Our ref: D2018/41285

SSD 8667 – Goulburn Base Hospital Redevelopment

WaterNSW has reviewed the Environmental Impact Statement (EIS) prepared by City Plan Strategy & Development Pty Ltd (dated 5 March 2018) and supporting documentation, and has the following comments:

Drawing Title  
**SEDIMENT AND EROSION CONTROL PLAN FINAL WORKS**

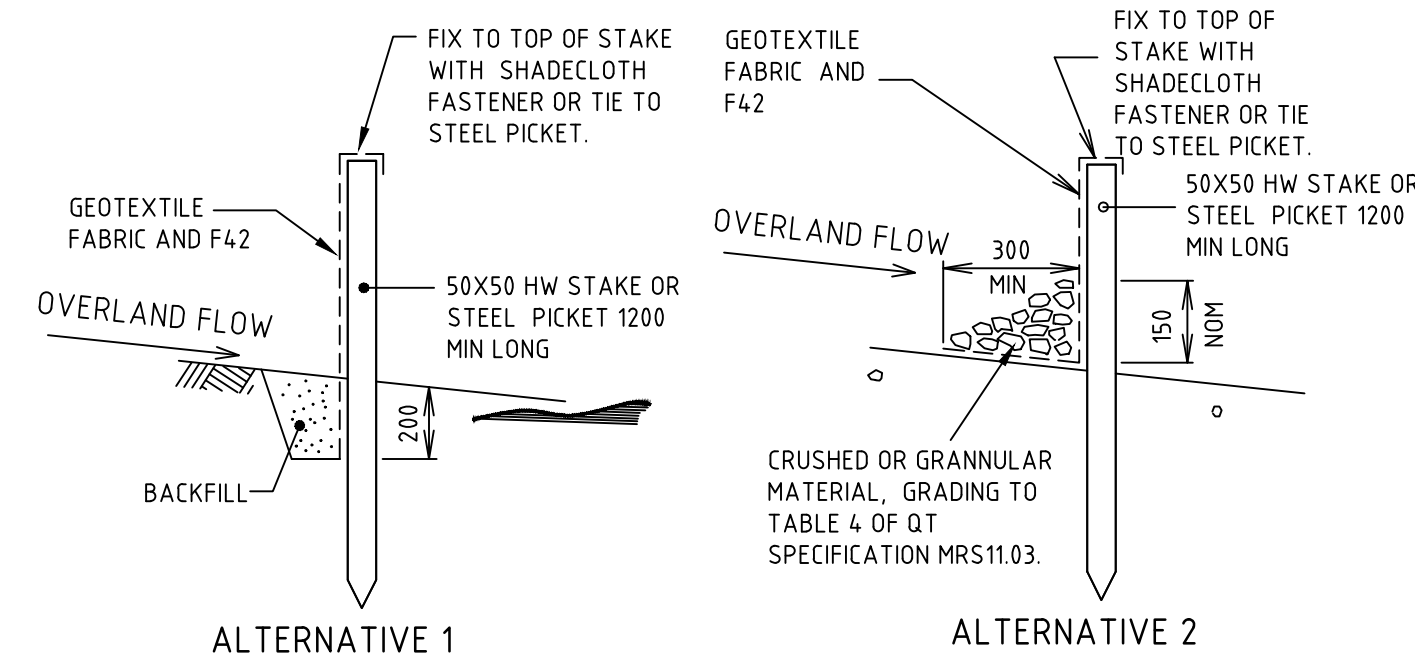
- An Operational Environmental Management Plan (OEMP) for the monitoring, management and maintenance of stormwater structures shall be prepared in consultation with WaterNSW.
- Given the site disturbance is more than 2,500 square metres, Sediment and Erosion Control Plans prepared by Bonacci Group (NSW) Pty Ltd shall be updated to Soil and Water Management Plans.
